From: Amanda Scholes on behalf of Planning.Responses
Sent: 20 November 2018 08:08
To: Planning Scanning
Subject: FW: A/106/18/PL - Somerset House, Angmering

From: Andrew Wood
Sent: 19 November 2018 17:10
To: Planning.Responses
Subject: FW: A/106/18/PL - Somerset House, Angmering

client	project	drawing	date	drawn	drawing no	revision
Julie Cleasby	Change of use at Somerset House, High Street Angmering, BN16 4AG	Location & Site / Block Plan	Mar 18	pd	0225 / 101	C
			scale	CAD file name:		
			1:200, 1:100, 1:1250 @ A3

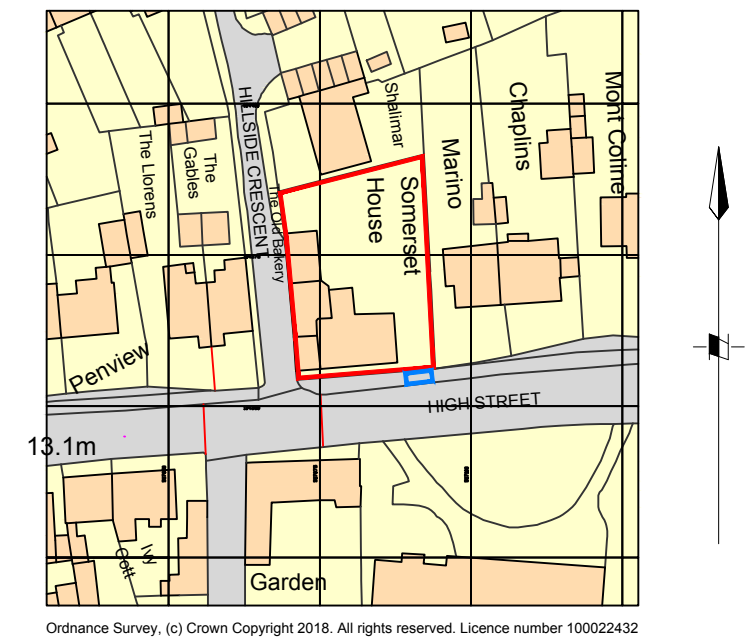
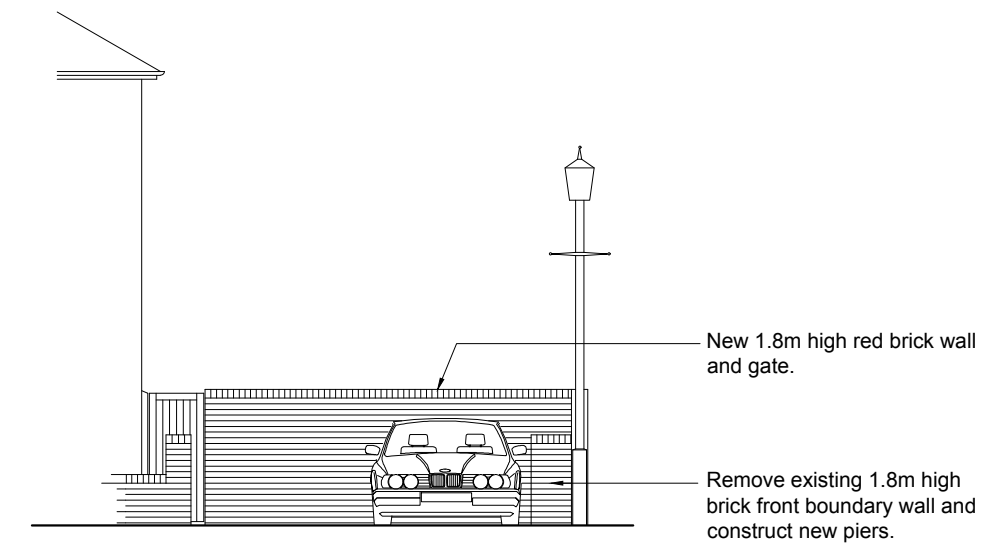
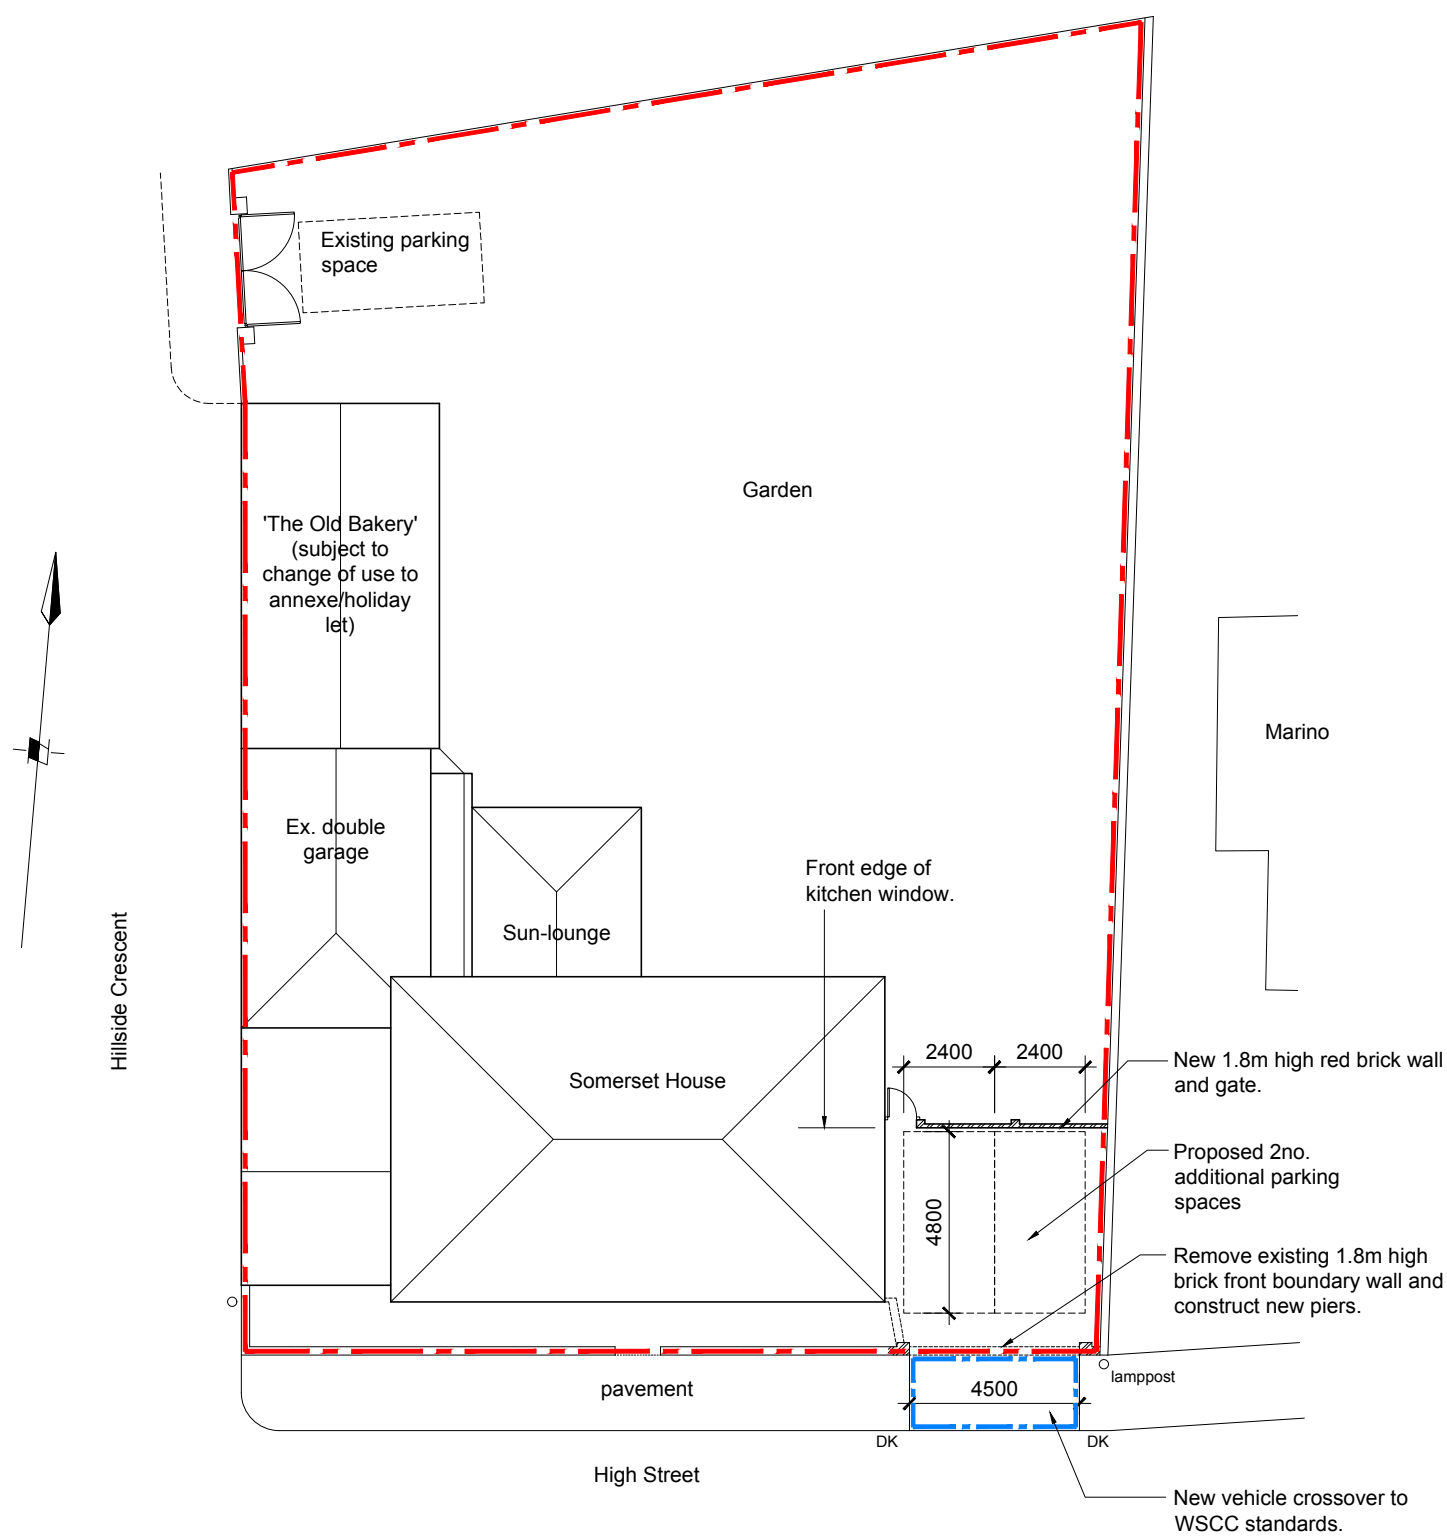
The demolition of the front wall and creation of two parking spaces at the front of the dwelling has attracted objections from both the Conservation Officer and the Conservation Area Advisory Committee. It is considered that this part of the scheme is contrary to policy in the Arun Local Plan and Angmering Neighbourhood Plan relating to Conservation Areas.

Can I request that you remove this element of the scheme. It might be possible add a further parking space at the rear of the property where a single existing parking space is shown on dwg.no. 0225/101 C
